Rezoning Transportation Analysis

Petition Number: 2024-018

Date	Description
03-27-24	First Review (KC)

# RZ-1.0

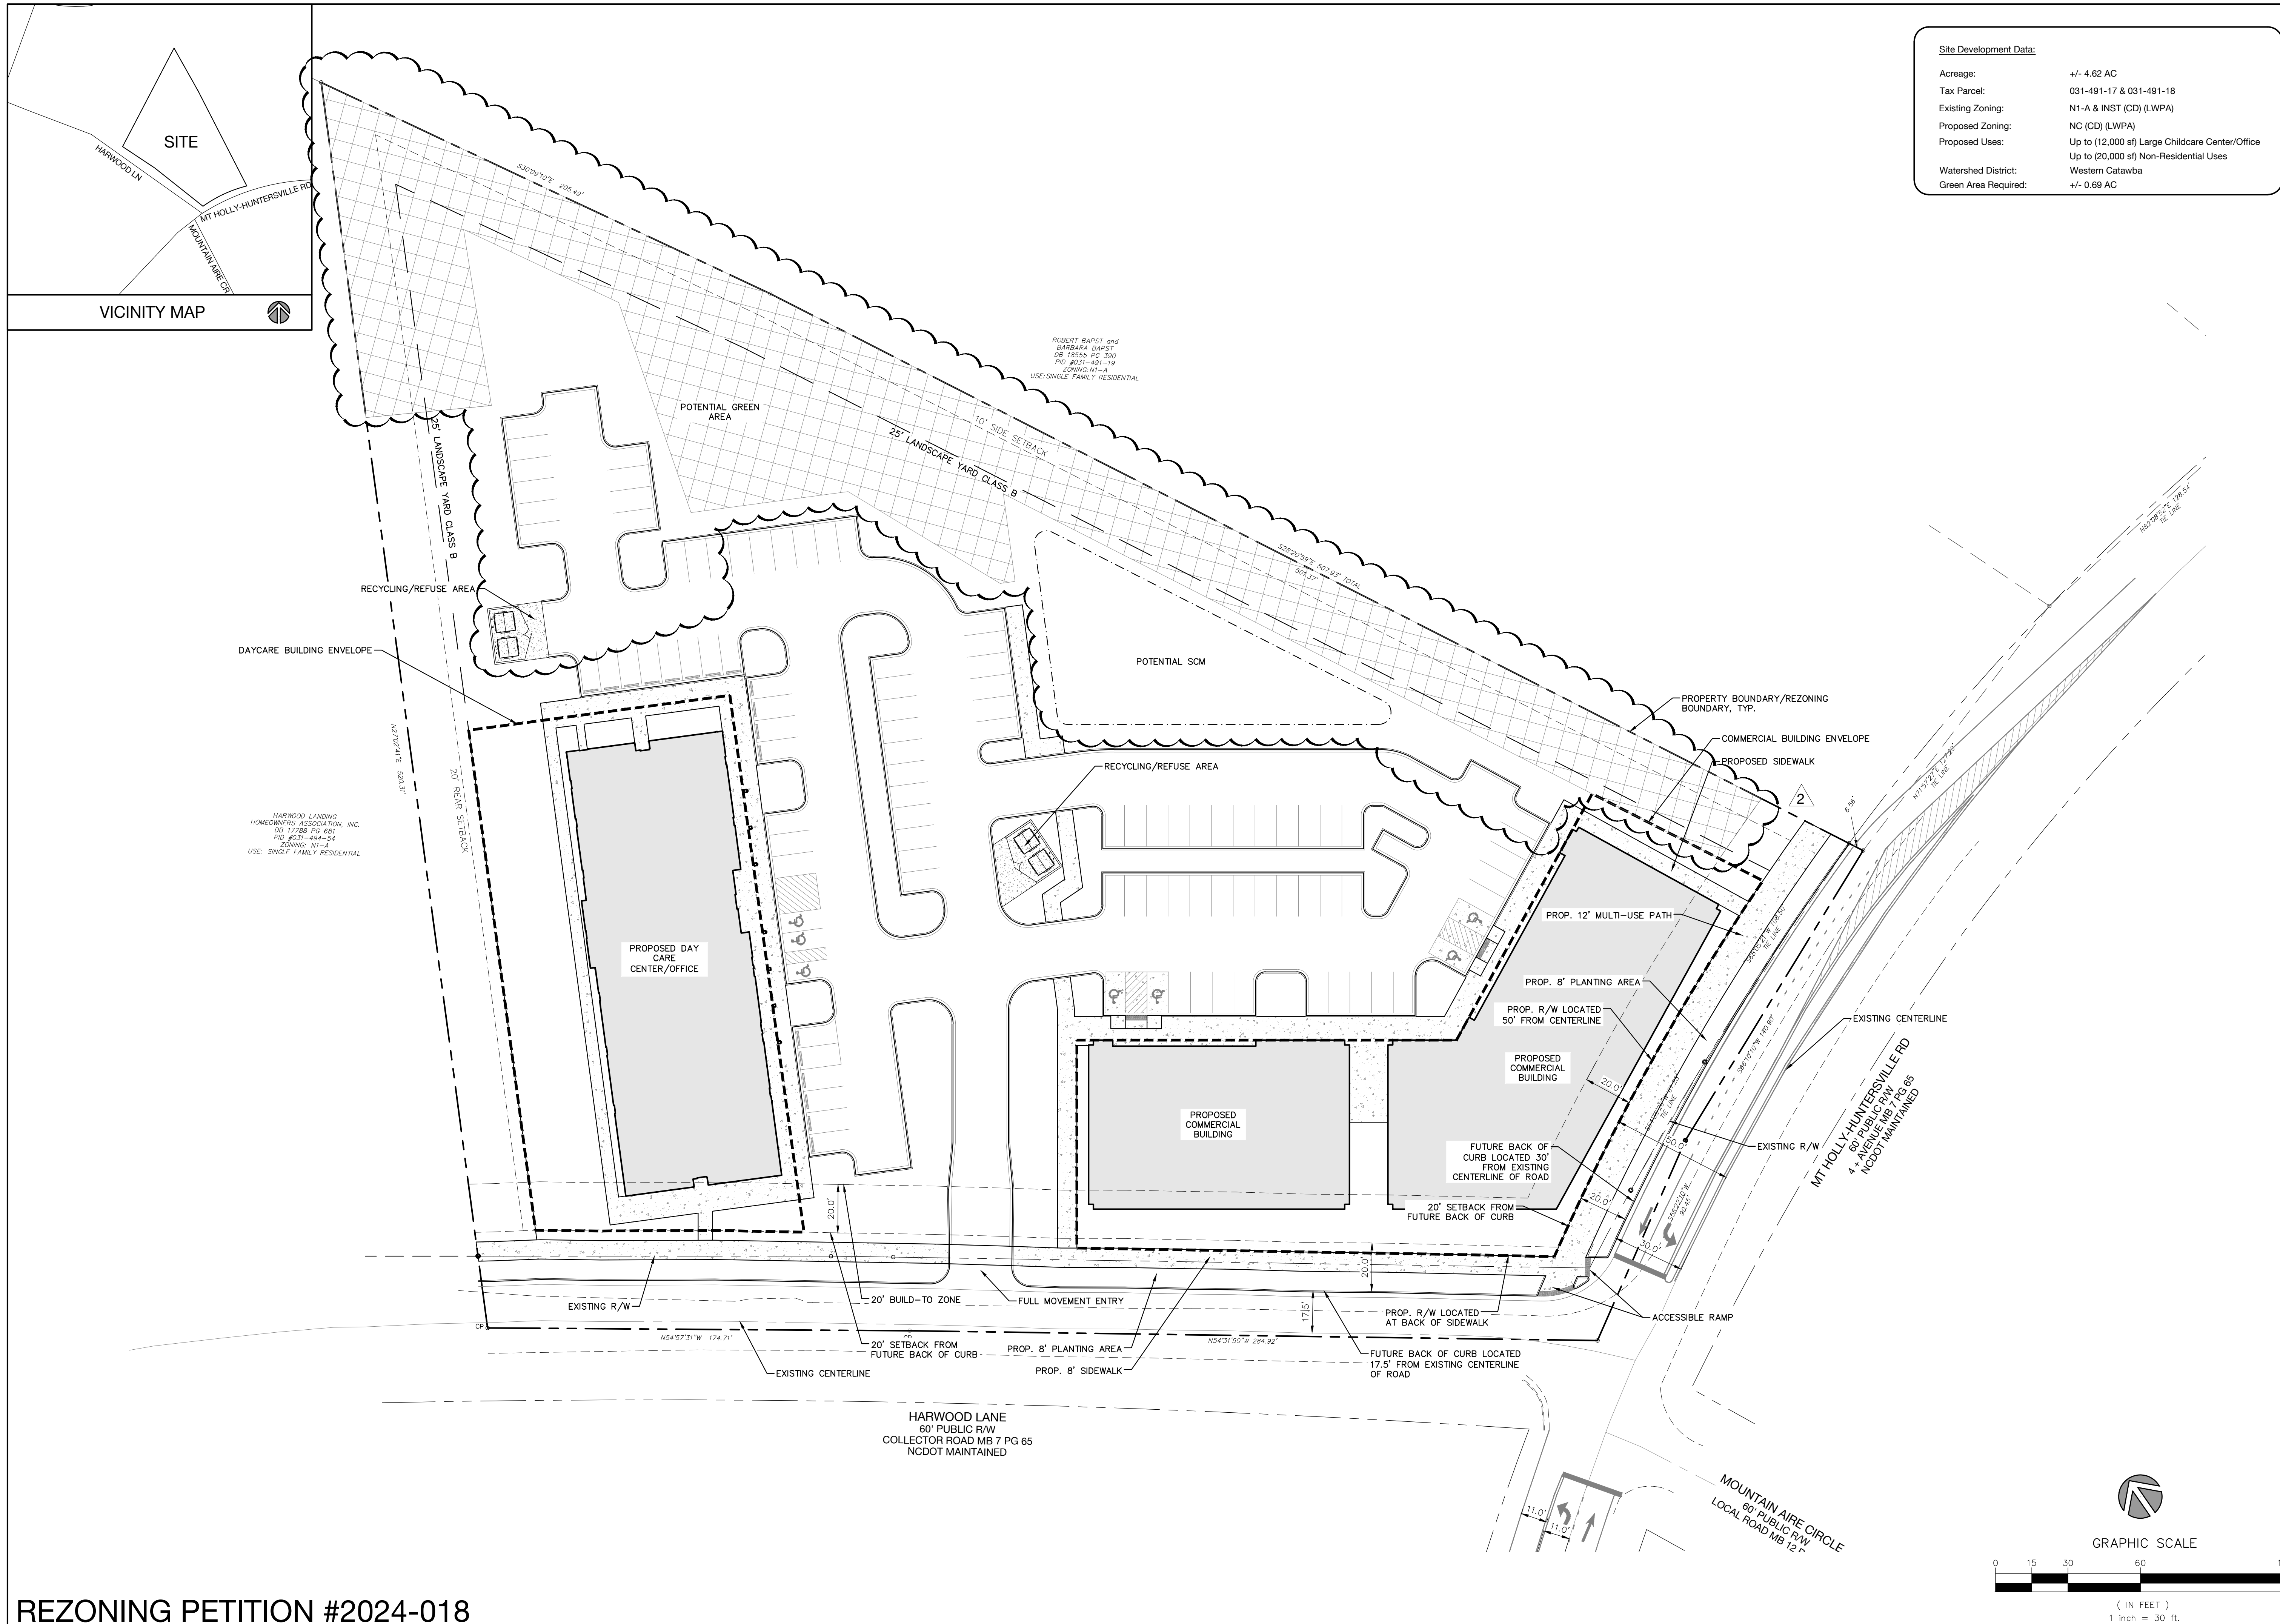
2. Comprehensive Transportation Review (CTR):

A Traffic Impact Study (TIS) is not required for the complete review of this petition due to the site generating site trips under ordinance thresholds found in the Charlotte Streets manual Table 3.1 and/or not triggering any other City TIS requirements.

The petition's zoning falls within the medium to high intensity development which based on the 1,645 daily trips will trigger Tier 3 (14 mitigation points) for multimodal assessment and Tier 3 (6 mitigation points) for transportation demand management assessment. The petitioner shall review and assess the publicly accessible pedestrian network within ¼ mile walking distance of the site to identify multimodal infrastructure to meet the Tier 3 (14 mitigation points) for multimodal assessment. Petitioner shall also provide transportation demand management strategies to meet Tier 3 (6 mitigation points) to reduce vehicle trips and encourage alternative modes of transportation.

See Table 3.3 Multimodal Assessment Mitigation Options in the Charlotte Streets Manual for guidance. Complete CTR summary table and include on the revised plan. CTR table link (use Site Data Table – CTR Summary tab): <https://www.charlottenc.gov/files/sharedassets/city/v/2/growth-and-development/documents/dev-center-fees/resources/udo-site-data-tables-curb-ramps-and-ctr.xlsx>

RZ-1.0

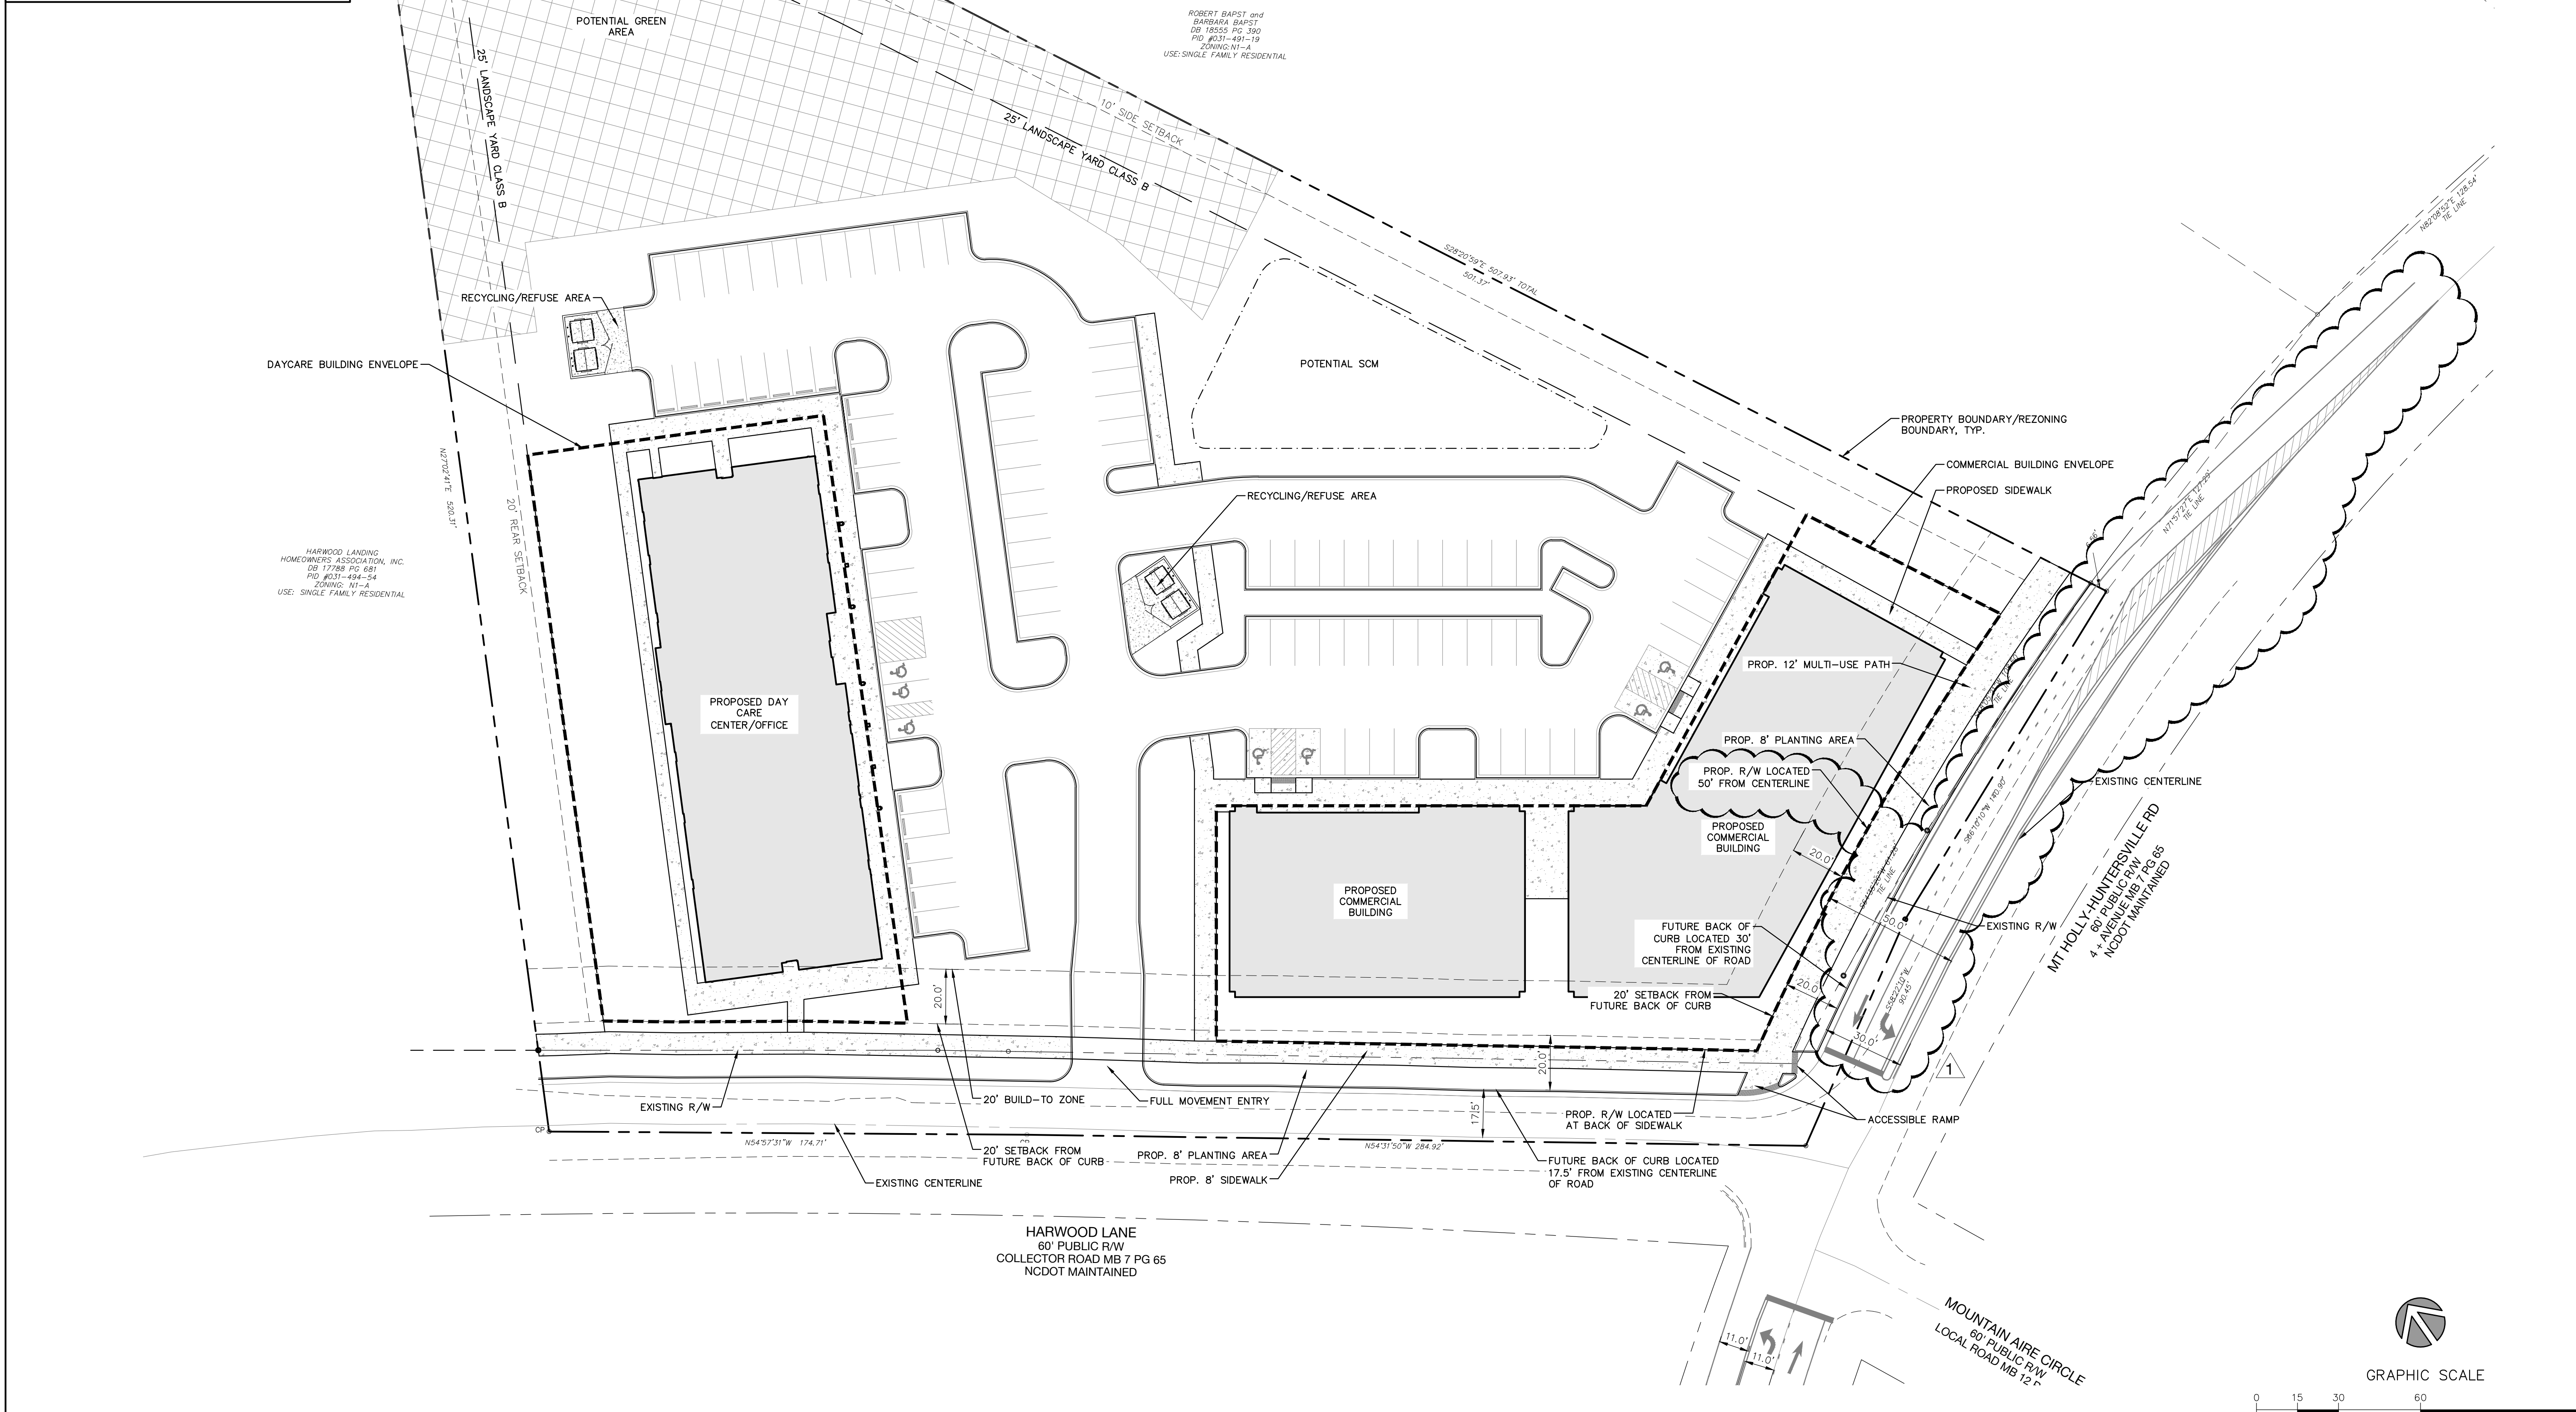
1. Curblines:

- a. **Mt Holly-Huntersville Rd:** The future location of curb and gutter is 30' from centerline.

4+ Avenue, Shared Use Path per the Charlotte Streets Map

- b. **Harwood Lane:** The future location of curb and gutter is 17.5' from centerline.

CLDSM standard Local Collector Street U-07B

Label and dimension the curb and gutter from the centerline for each road on the site plan. Show proposed striping layout for Mt Holly-Huntersville Road and commit to restriping for left turn lane on Mt Holly-Huntersville Road at Harwood Lane.

3. Revise site plan and conditional note(s) to commit to label and dimension the proposed dedication of 50 feet of right-of-way from the Mt Holly-Huntersville Road centerline.
